LORSON RANCH
Carriage Meadows North Landscape Plan

DSD FILE NO.: SF 17-023

Lorson Ranch
Carriage Meadows North
Colorado Springs, CO
PRELIMINARY LANDSCAPE PLAN

Markup Summary

# Carriage Meadows North Landscape Preliminary Plan

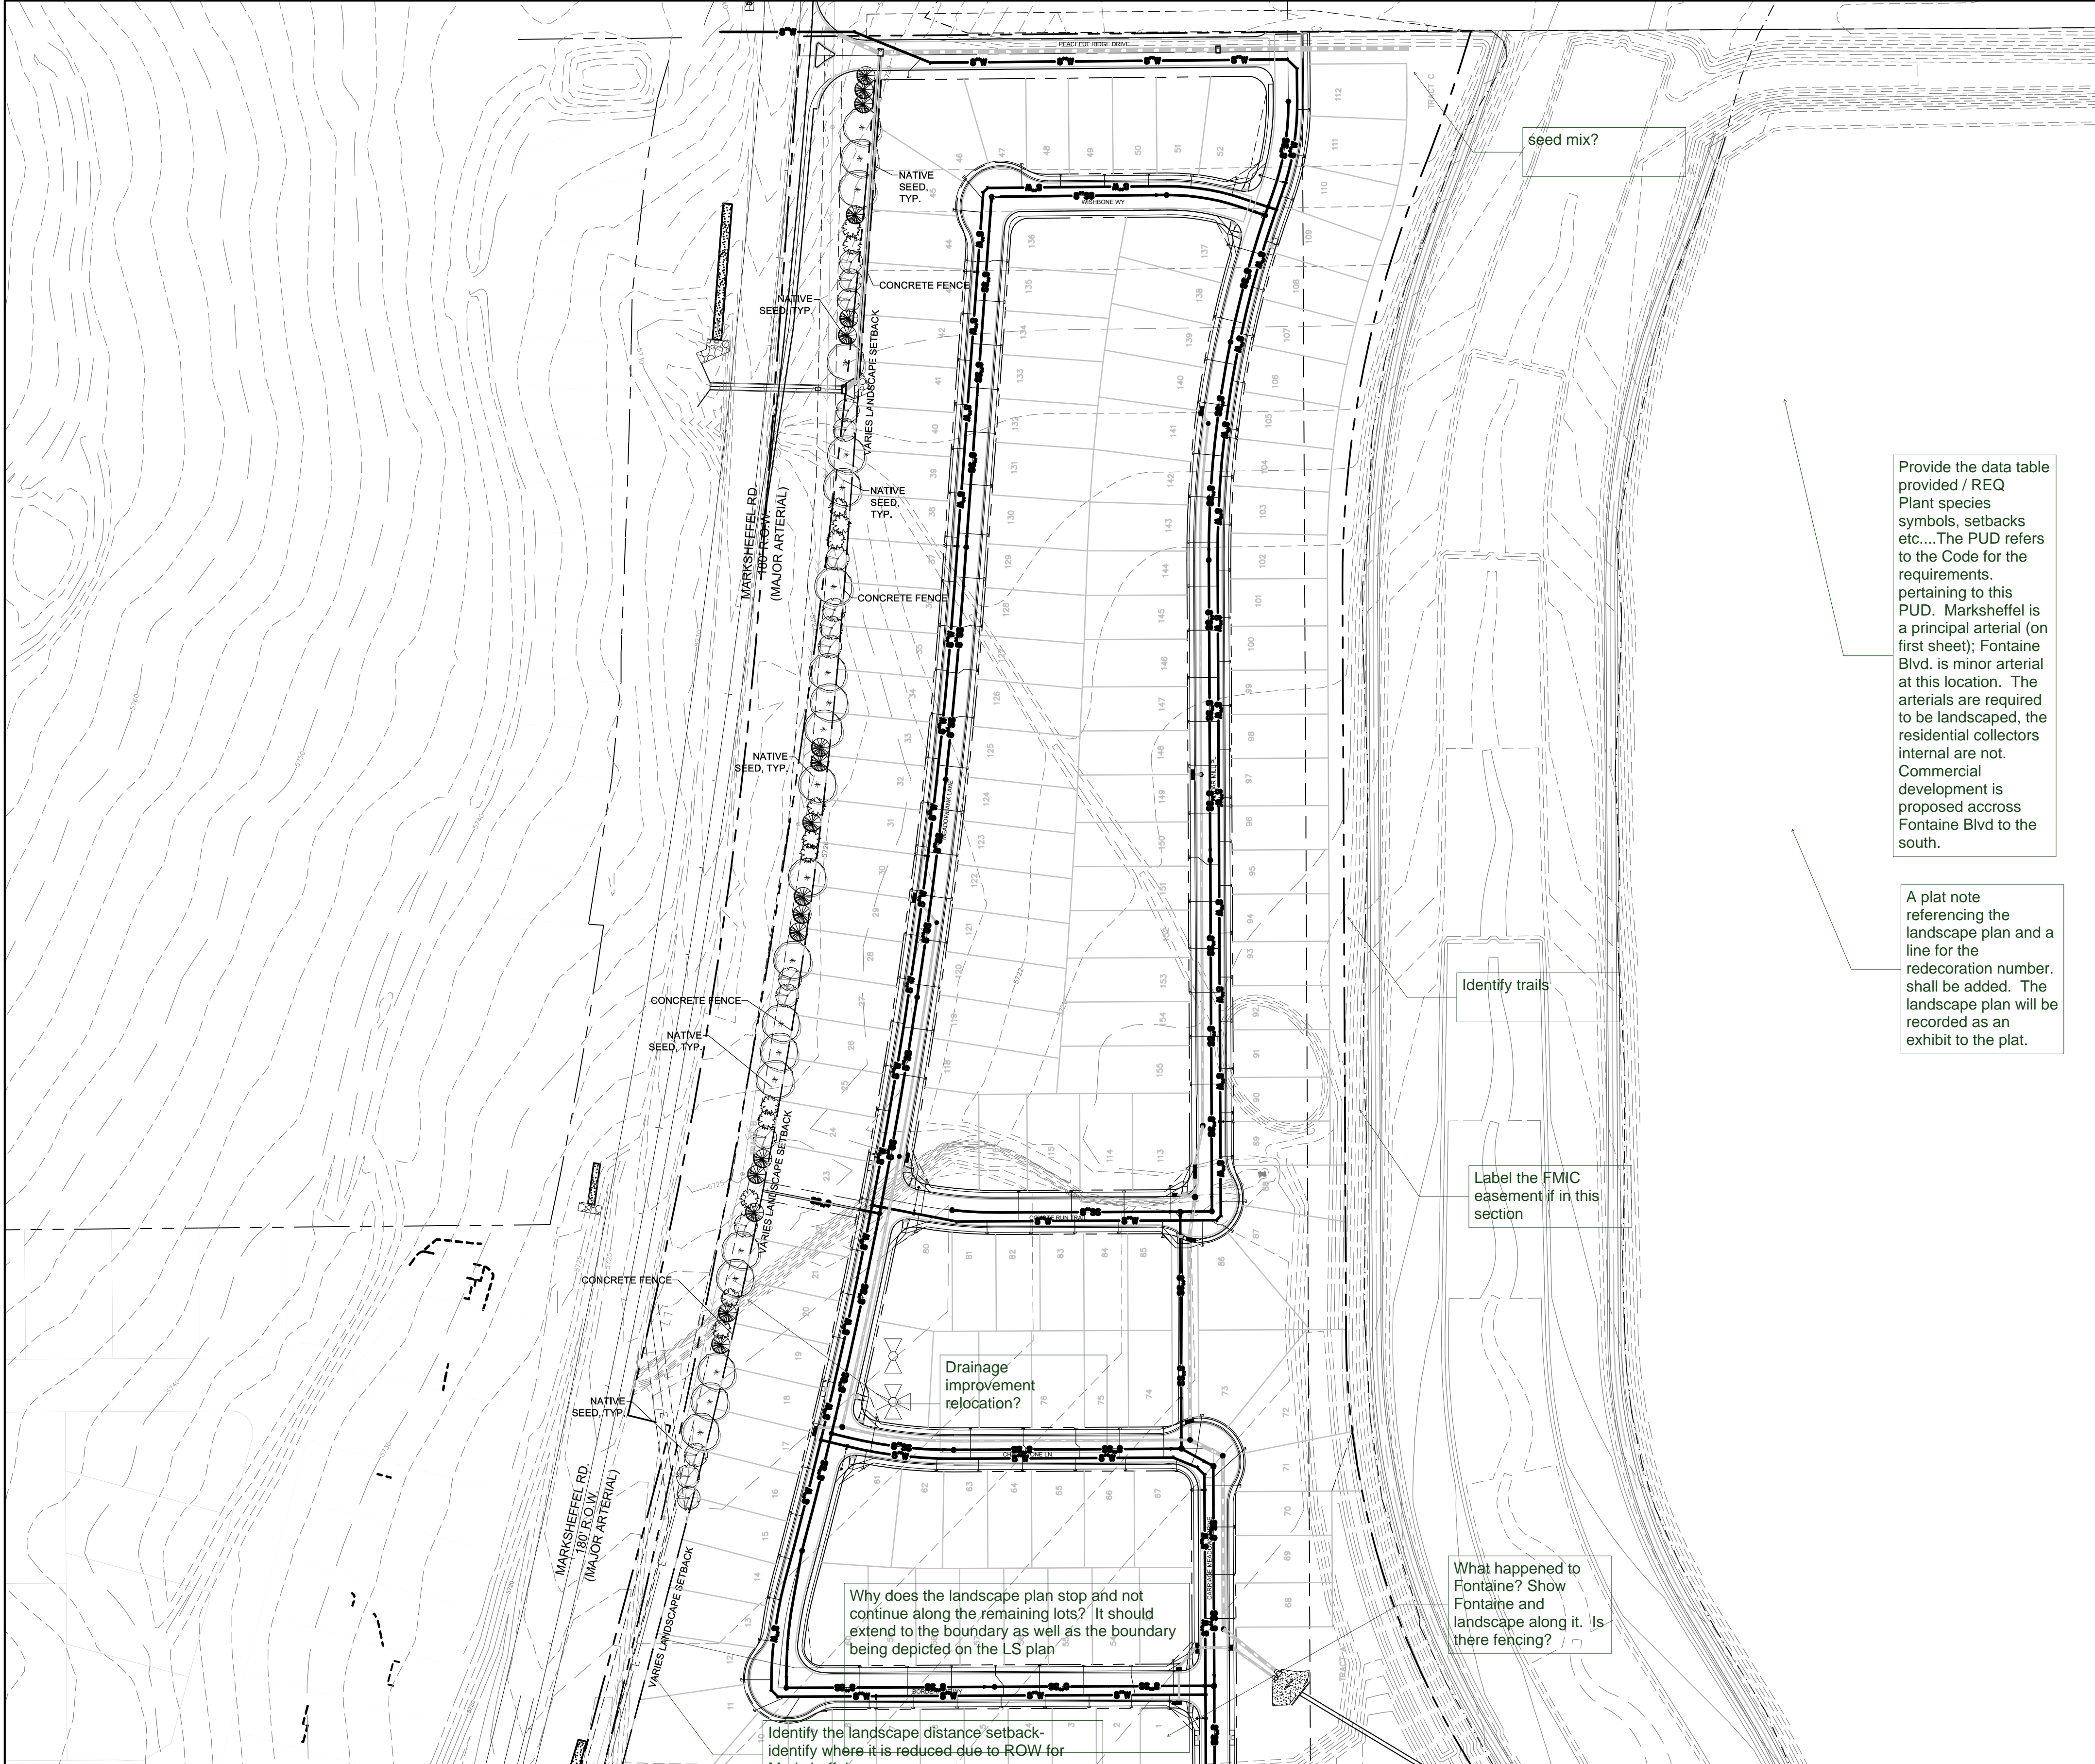
Add a line item for Fontaine and the waiver to defer until those tracts are platted so there is a record. Cover in LOI also.

The Marksheffel waiver is not supported by staff at this time. No justification was provided and that was not agreed to during discussion at he EA about not requiring a PUD amendment due to the reduction in the landscape buffer due to the road widening.

add "due to Marksheffel Road widening"
